5. Landscape & Visual Steeple Renewables Project

November 2025

**FIELDS FOR
FARMING**

## FIGURE 6.9 – LANDSCAPE AND ECOLOGICAL MITIGATION STRATEGY (SHEET 1 OF 6)

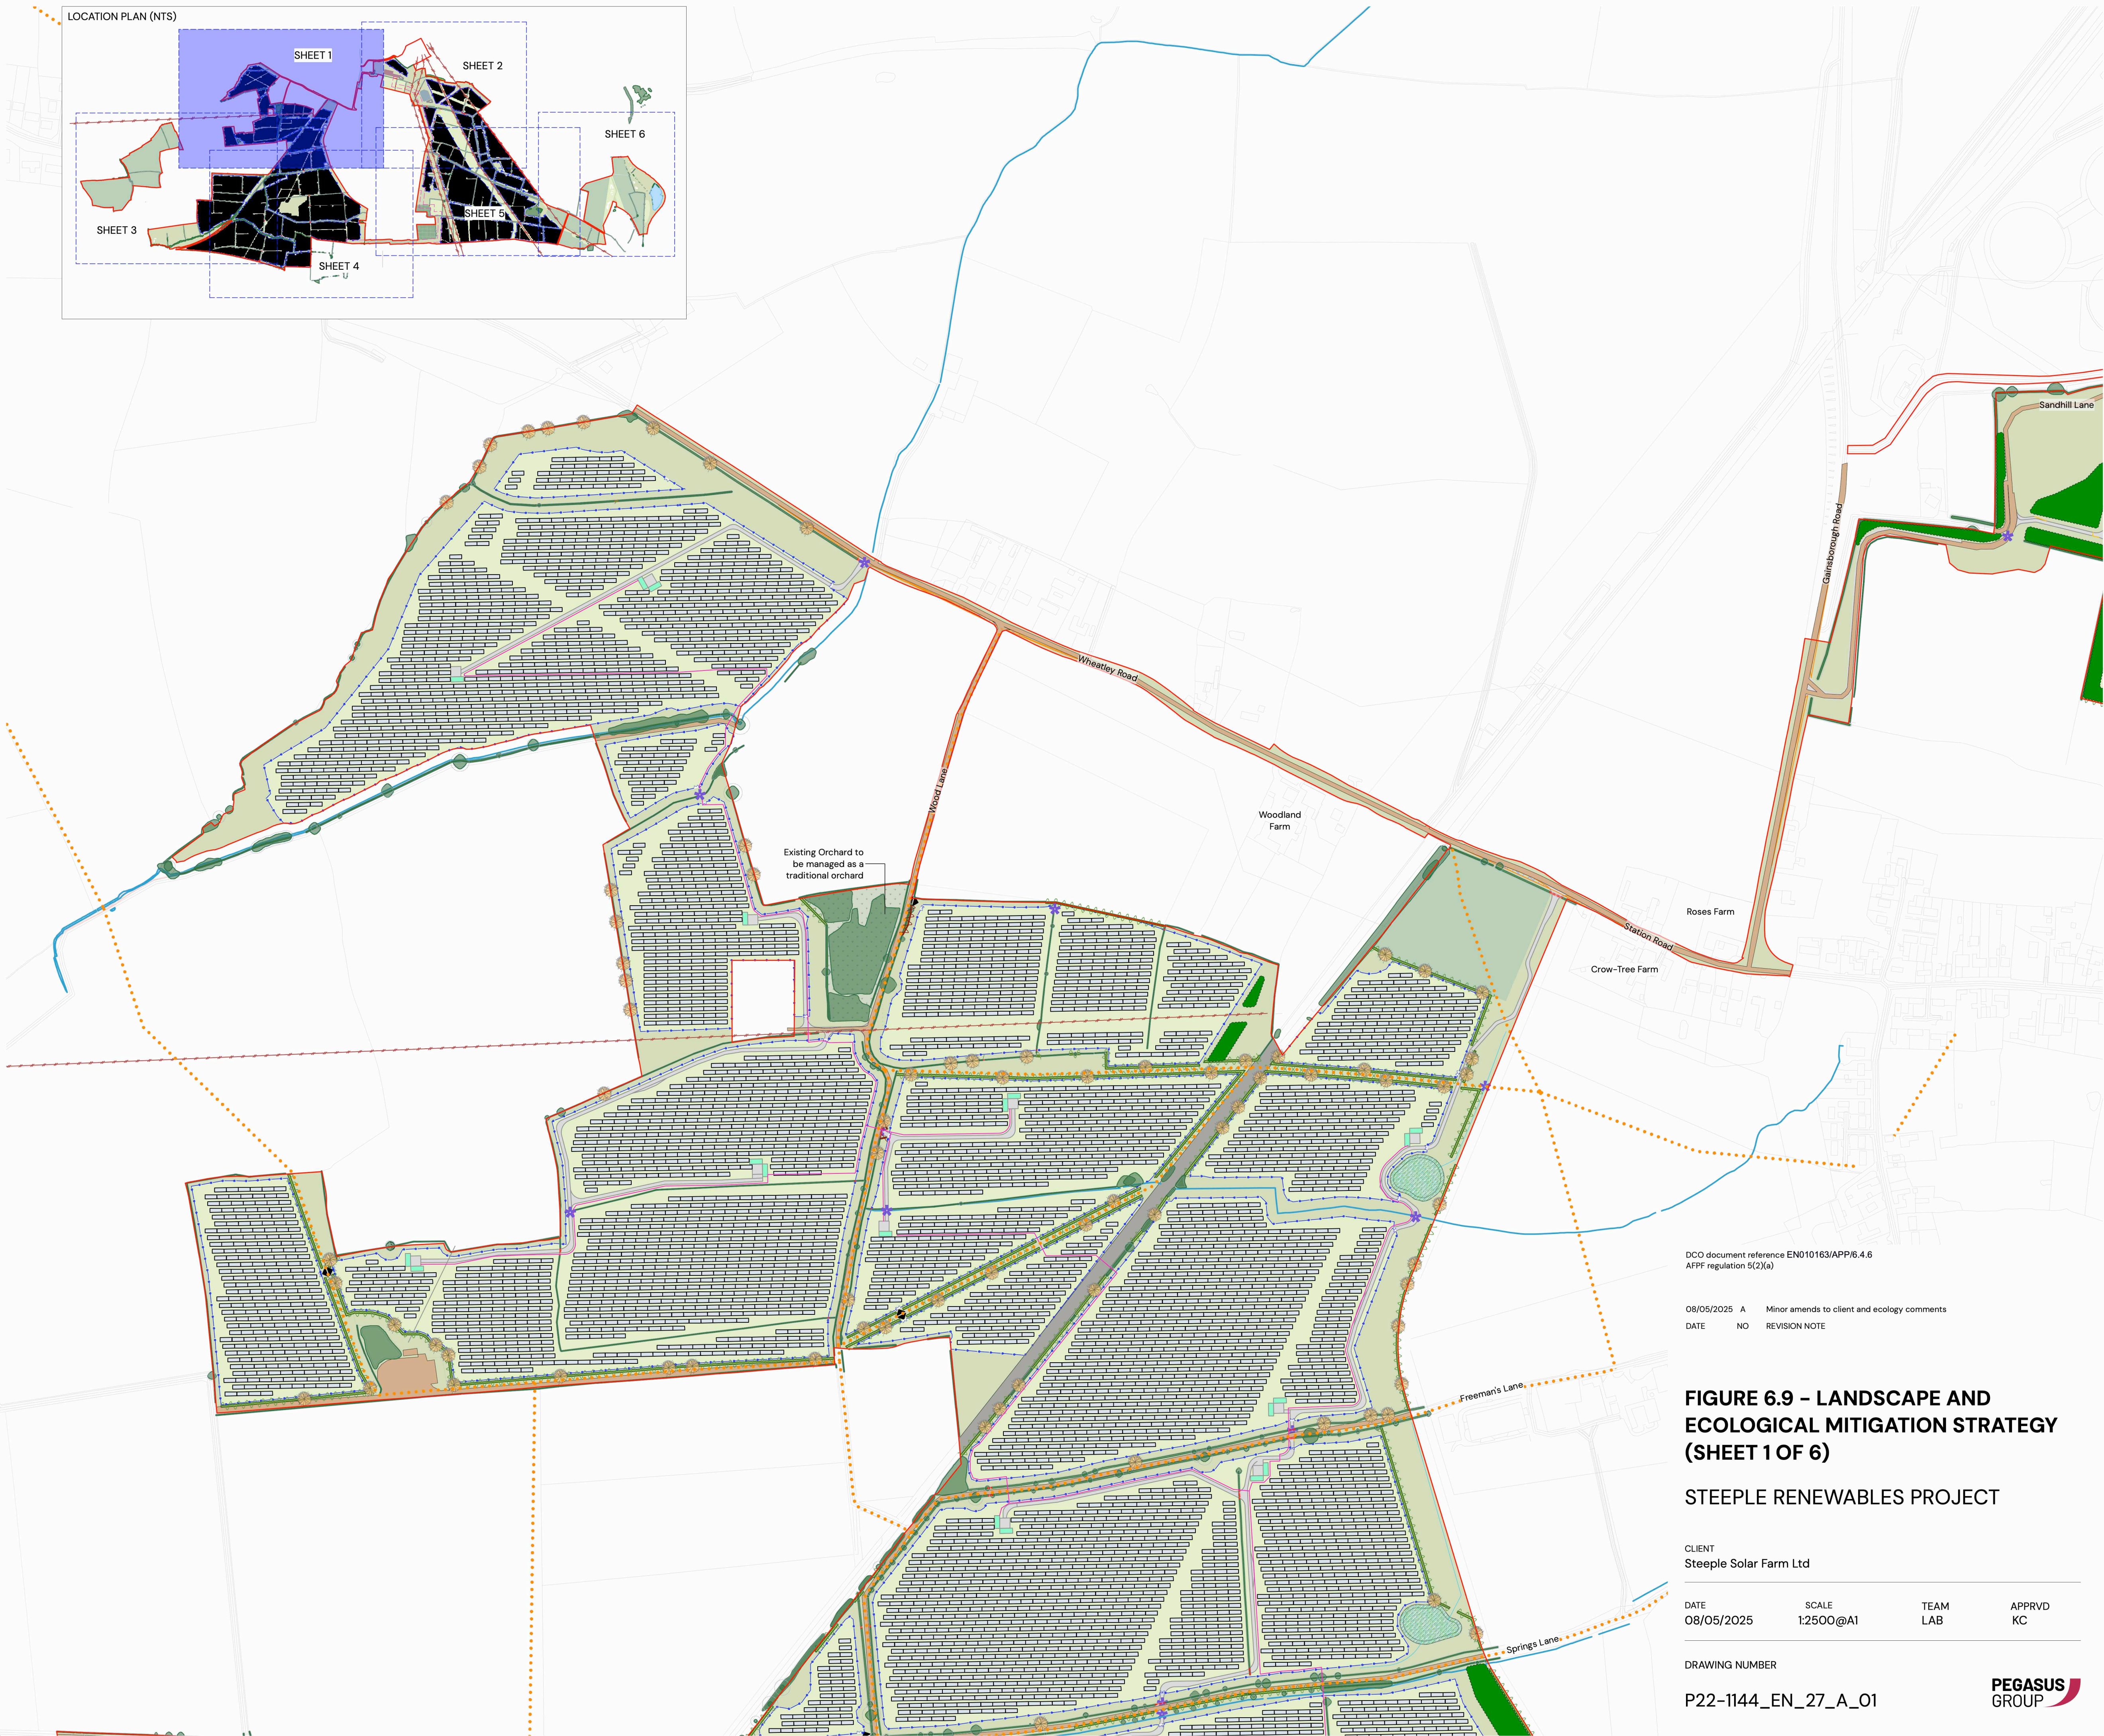
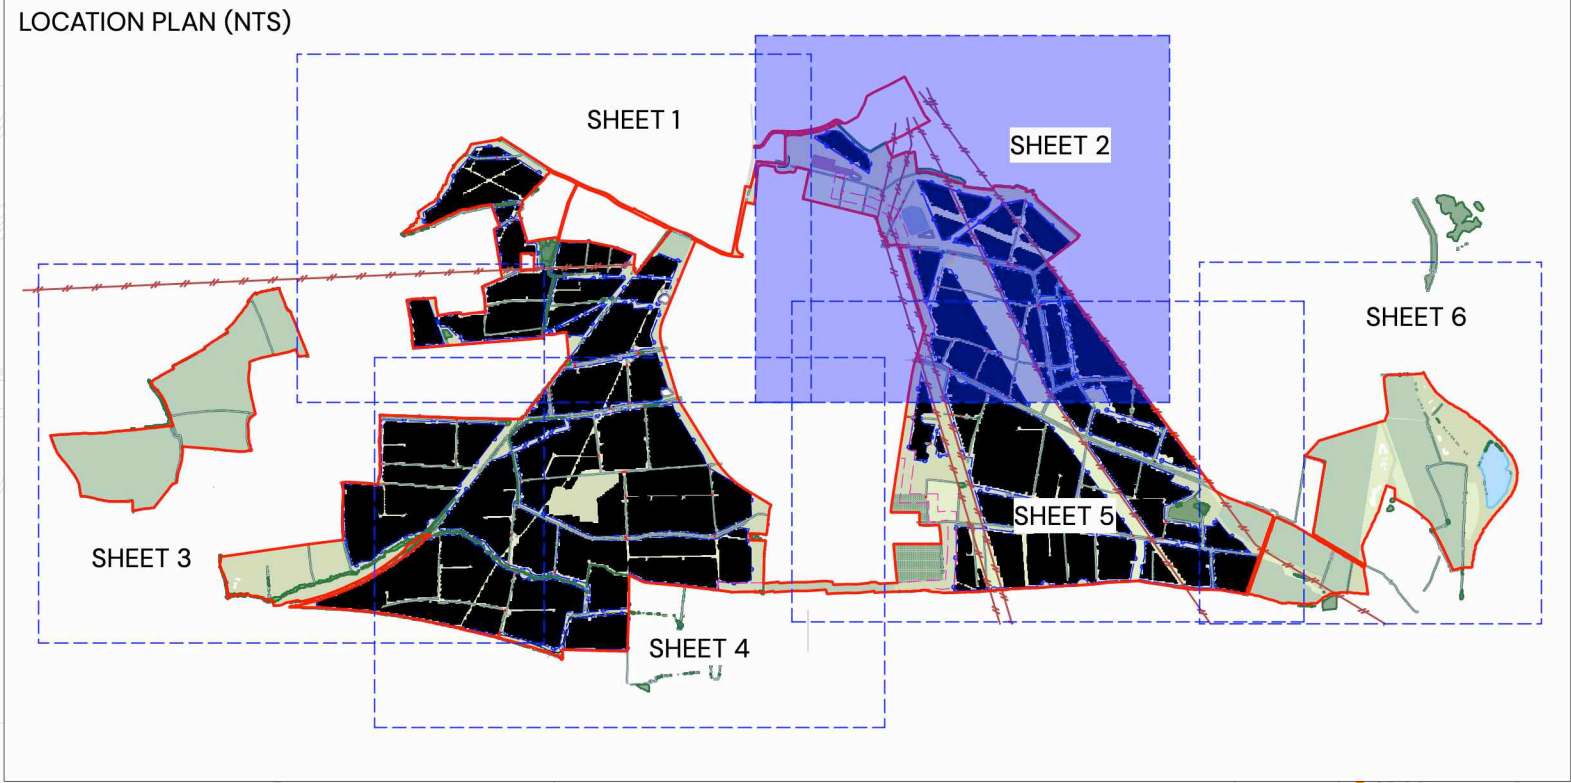
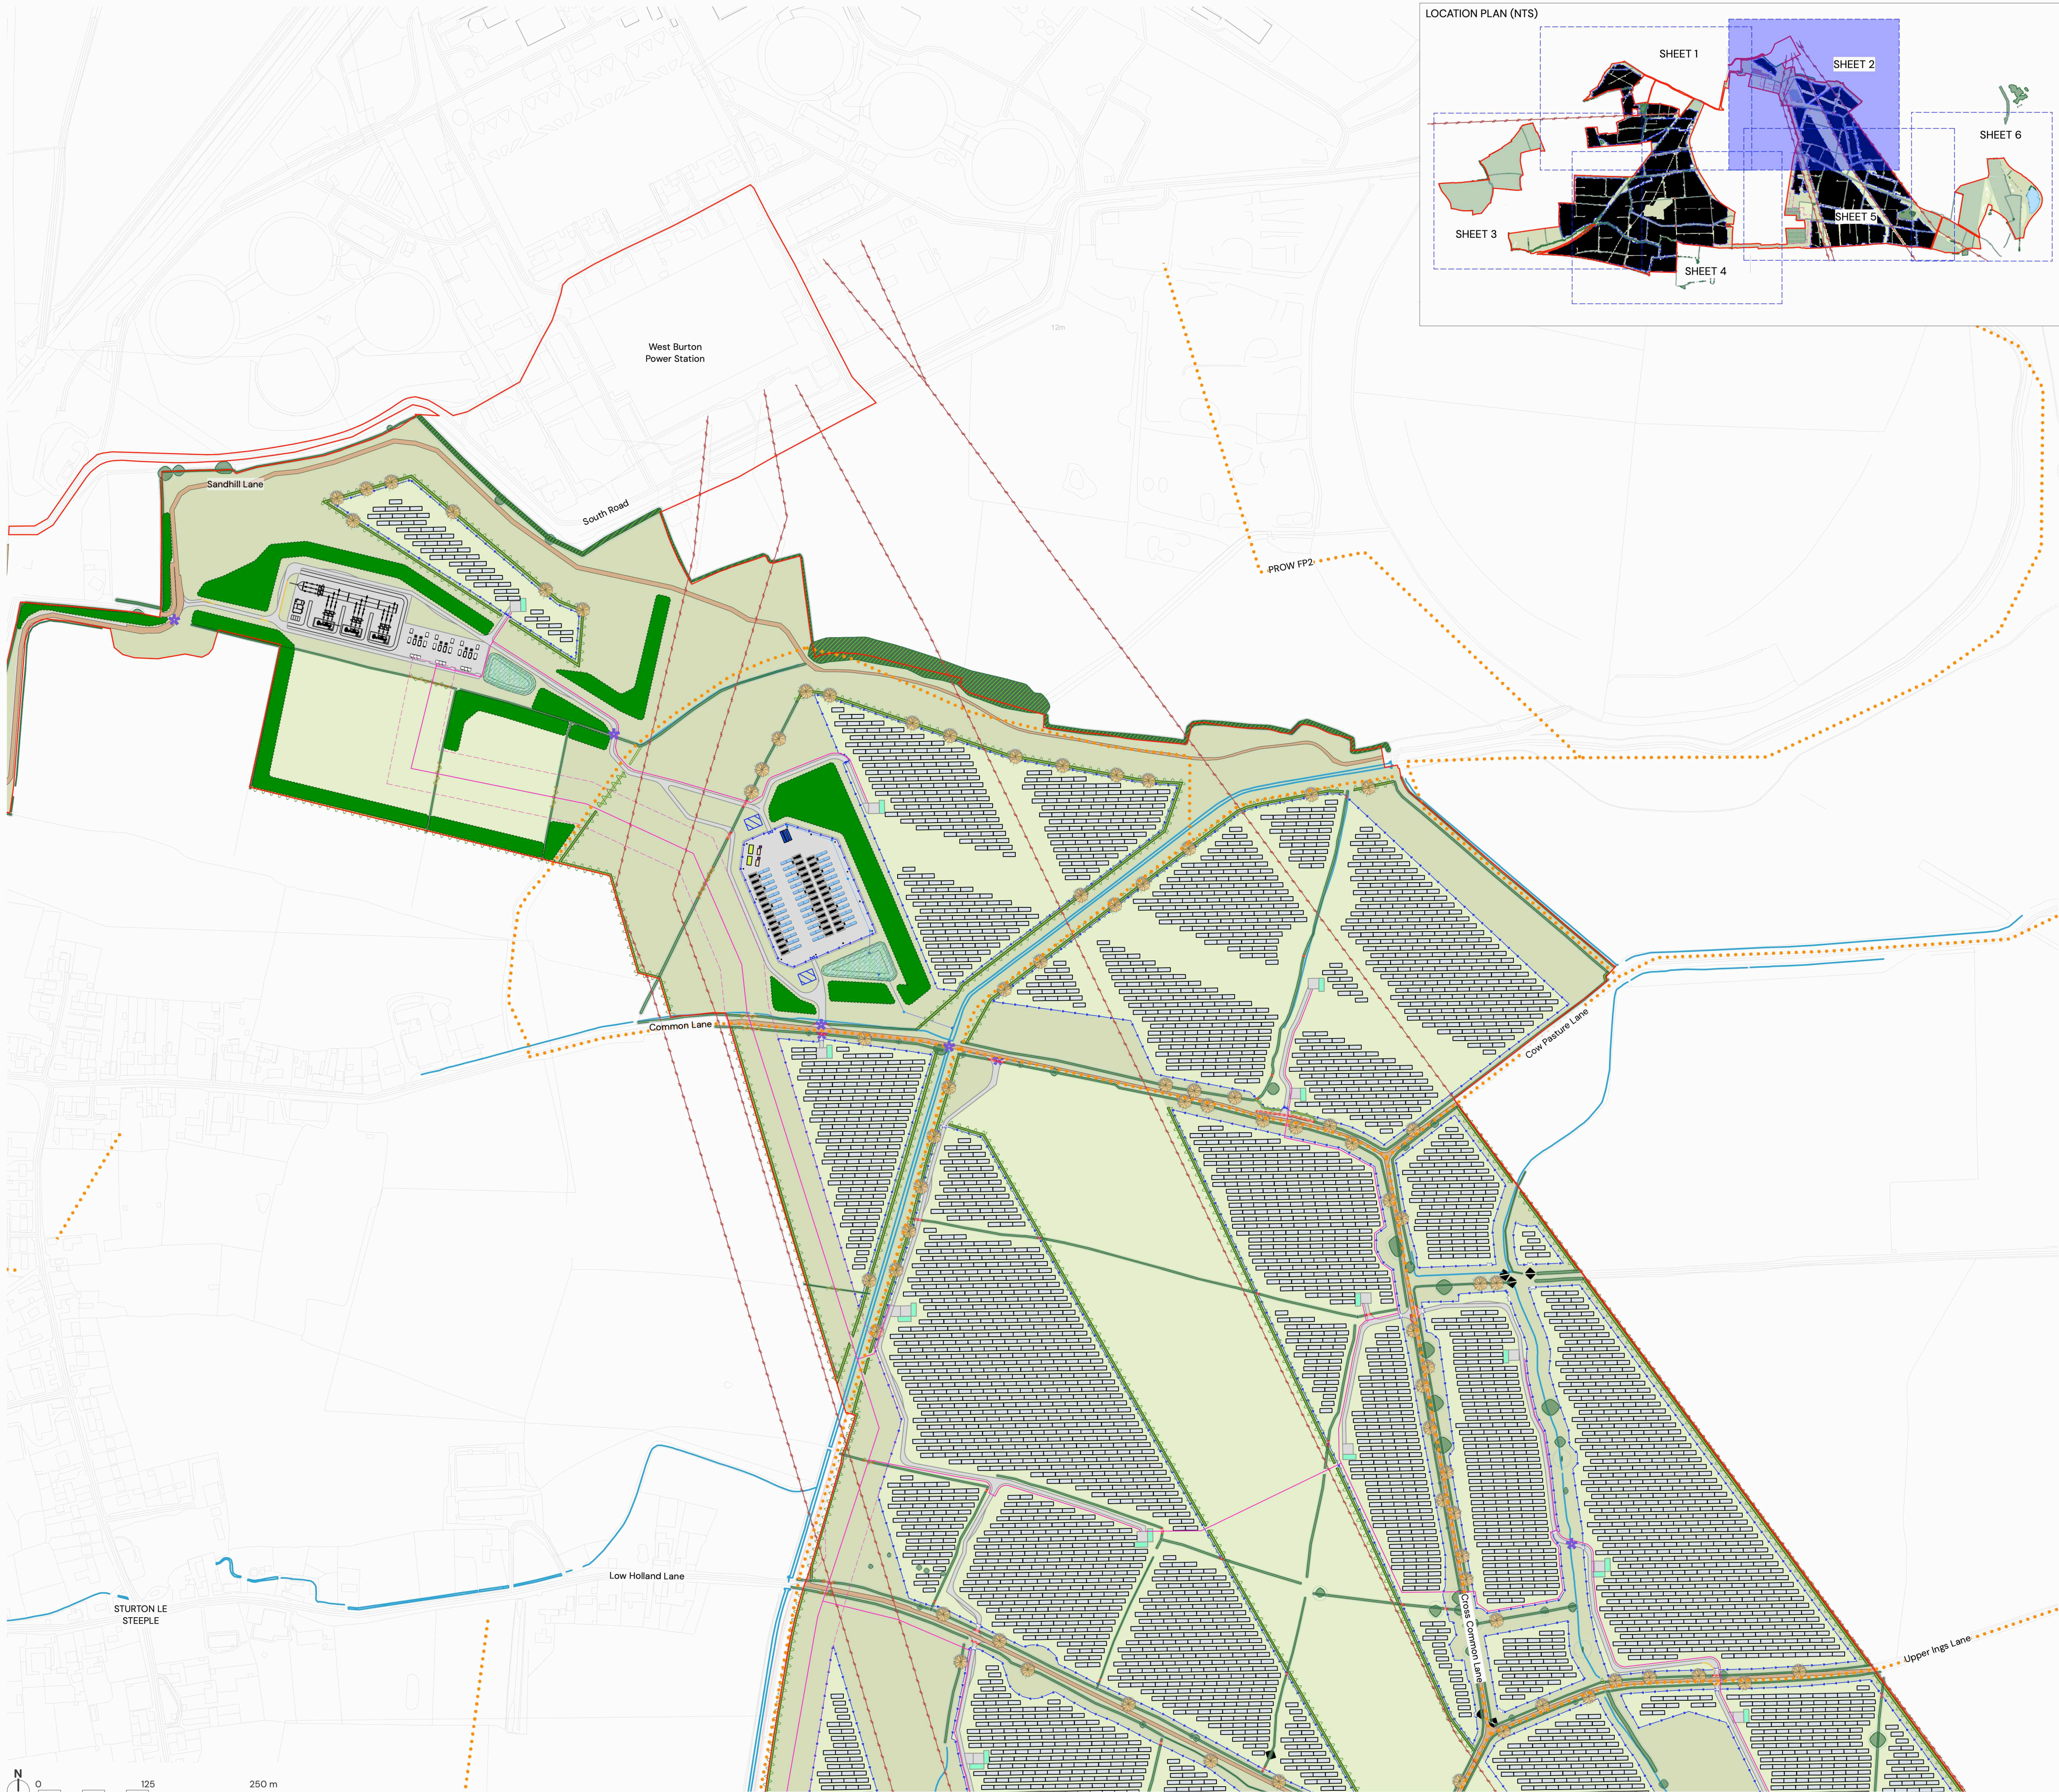
Numerous Public Rights of Way (PROW) and permissive paths intersect the Site and are shown on Figure 6.9 Outline Landscape Mitigation Strategy [EN010163/APP/6.4.6]. The maintenance of these has been considered in relation to their influence on habitat condition, for example greater hedgerow cutting frequencies may be needed adjacent to PROW, but management prescriptions for the PROW have not been specified, as they do not have their own ecological objectives.

It is difficult to determine from the above whether the hedgerows bordering the PROW will be managed or not or indeed in what manner which has an impact on visual assessment outcomes, and how their impact on NBG can be assessed if the management of them is not determined.

The applicant confirmed they intend to plant/allow existing hedgerows to grow either side of Trent Valley Way and other PROWs. These hedges will be allowed to grow to 3m high, and it is not clear how often these hedgerows will be maintained. The applicant claims this will still afford pleasant and open views. This is simply not true, the proposed 15m wide routes with 3m hedges will not feel "open and pleasant" in a rural landscape; they create a confined, engineered corridor that fundamentally changes the character of the Trent Valley Way and public right of way.
